RE. Development of 3A Dawlish Drive, Ruislip HA4 9SF

Planning Ref. 14032/APP/2021/2749 Your Ref. ENF/753/22

Mr Leckie as the Enforcement Officer has noted 3 items on site which differs slightly from the deposited plans of the full application. Having looked at the 3 items, I wish to explain these small variances and the decisions behind them. With this information I would respectfully submit a Minor Variation Application to the original Approved Drawings.

Sheet
06
Rev.
REV A

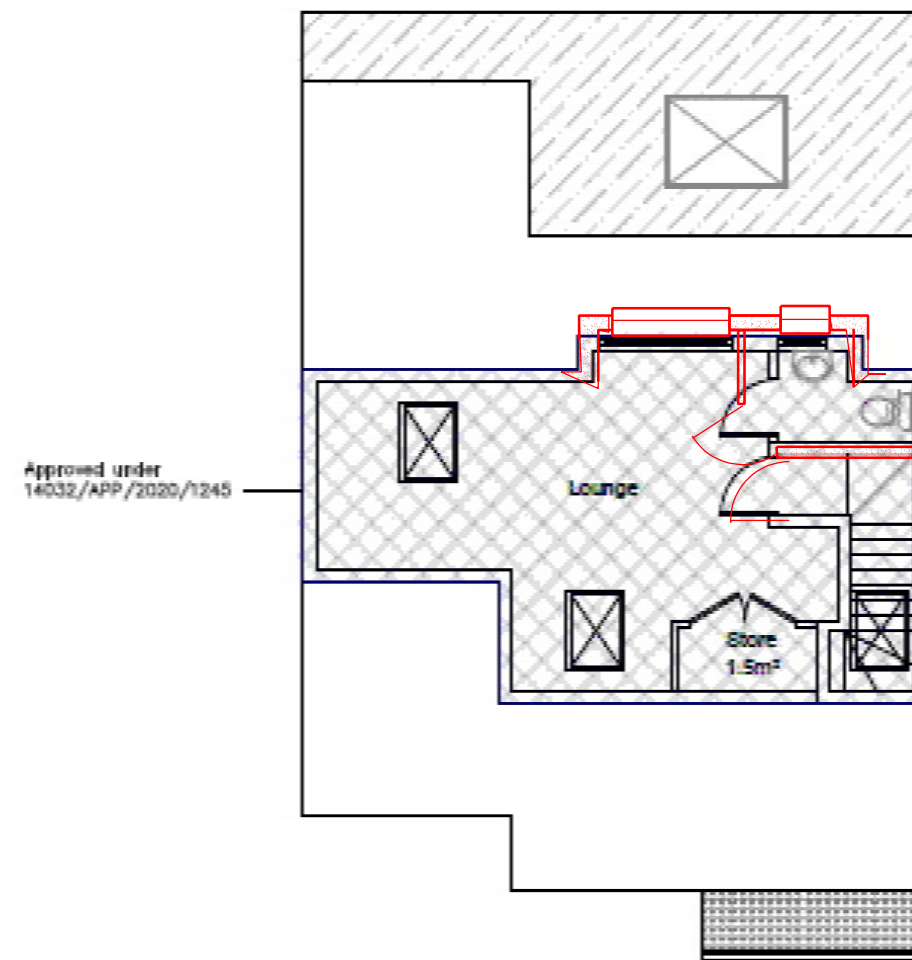
The reason of the small change is that the structural engineer placed the steel beam support for the floor, roof and dormer in a measured location and the contractor built off the beam resulting in the rear dormer wall being approx. 250mm closer to the rear of the building. This has enlarged the rear dormer wall downwards by approx. 200mm. and has not raised the dormer roof any higher than the Approved drawing, see detail photo below.

01

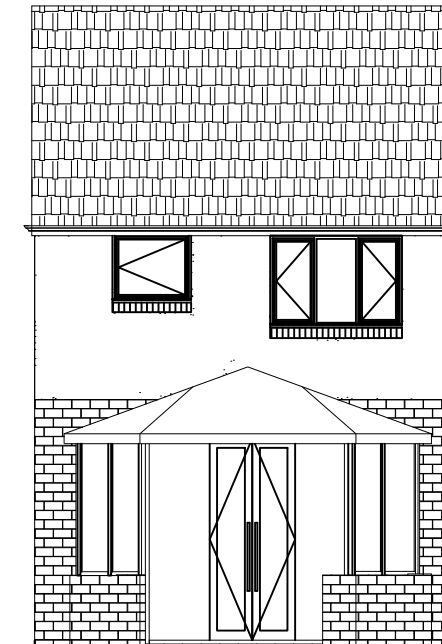
a) ***"Dormer roof extension larger in height than shown on approved drawing ... sheet 01"***

This photo shows dormer roof, existing roof ridge and new extension roof ridge. Also, the width of the dormer has not altered from the Approved Drawing, Revision shown on drawing 01 Rev A of the rear elevations.

b) "Doors fitted to the kitchen at first floor level instead of a window as shown on drawing ... sheet 01."

The doors indicated by Mr Lockie have been installed as a larger opening window and resulted from a last-minute design decision to increase the size of the kitchen / dining area window in response to an agreed minor internal layout change with the Building Control Inspector.

The new doors are considered as an enlarged window, opening inwards for greater ventilation and amenity. The doors/window are not a full door size due to the insulated roof externally. The doors are strictly not for access onto the adjacent flat roof. The flat roof is not configured for use as a balcony. An iron "Juliet" balustrade will be placed across the external side of the doors to prevent casual access onto the roof.

Please review drawing 01 Rev A Rear elevation.

Firm Name and Address Mohammad Hashim 3A Dawlish Drive Ruislip HA4 9SF	Project Name and Address 3A Dawlish Drive Ruislip HA4 9SF		Project 3ADD-HA4-9SF	Sheet 04 A
			Date MAY2023	
			Scale 1:100	
			Paper A3

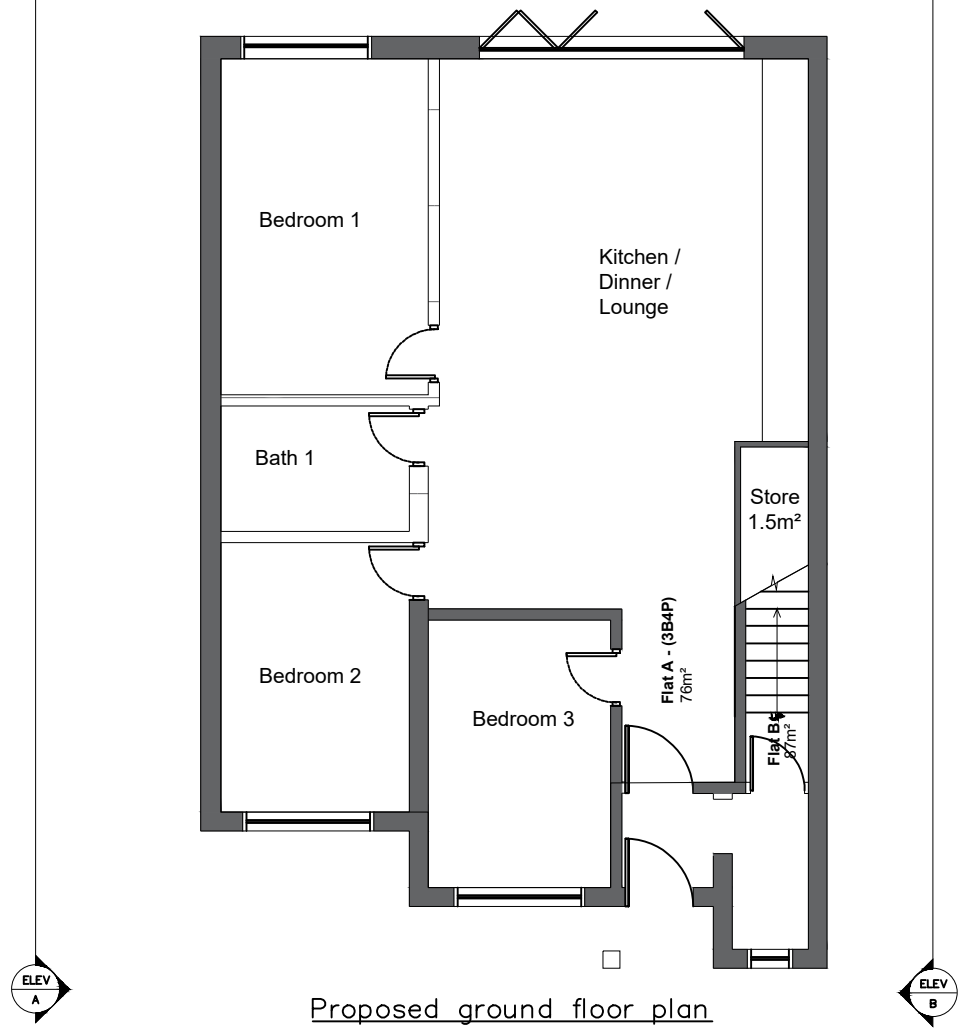
c) "The internal layout at both ground and first floor level changed, so as not to be in accordance with approved drawings ... 04 and 05 respectively."

The ground floor internal layout of corridor walls layout has been altered in discussion with the Building Control Inspector.

On discussion with Building Inspector
Omit screen wall as it reduces the living space to a poor layout.
The original layout does not provide a clear protected fire escape route as the kitchen is open to the hallway and bedroom access.

The doors into the two bedrooms already require 30/30 smoke/fire resistance and need sprung closers and positive latches. Escape has been agreed through the suitable fire escape windows as agreed with the Building Inspector. The kitchen units will now be situated against the eastern outer wall.

Please review revised drawing 04 Rev A ground floor plan

05

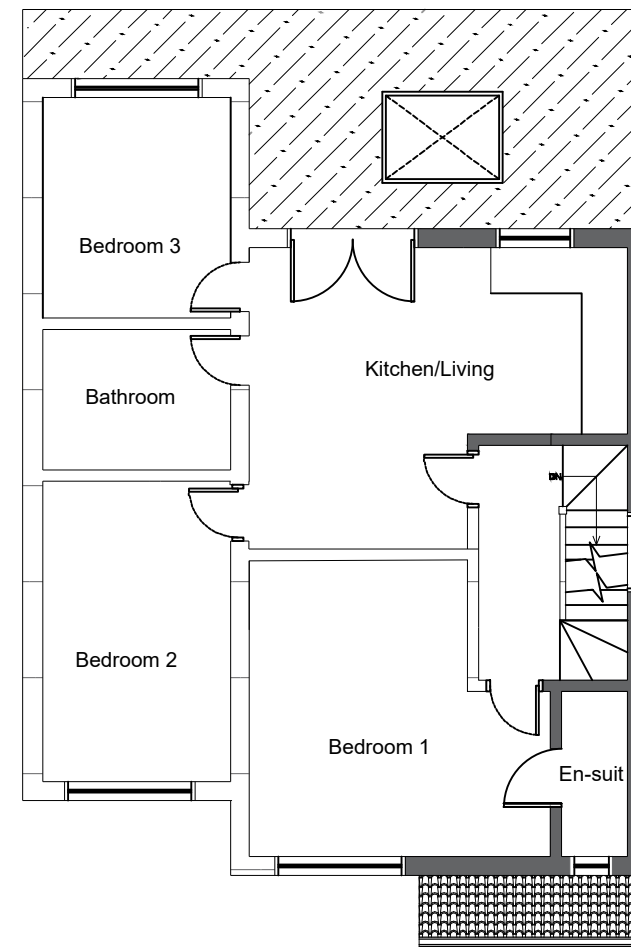
On discussion with the Building Inspector.
Omit internal walls to kitchen and bathroom.
Relocate bathroom to between the two bedrooms similar to the ground floor.
Kitchen to be relocate to where the bathroom is shown

Please review drawing 05 Rev A first floor plan
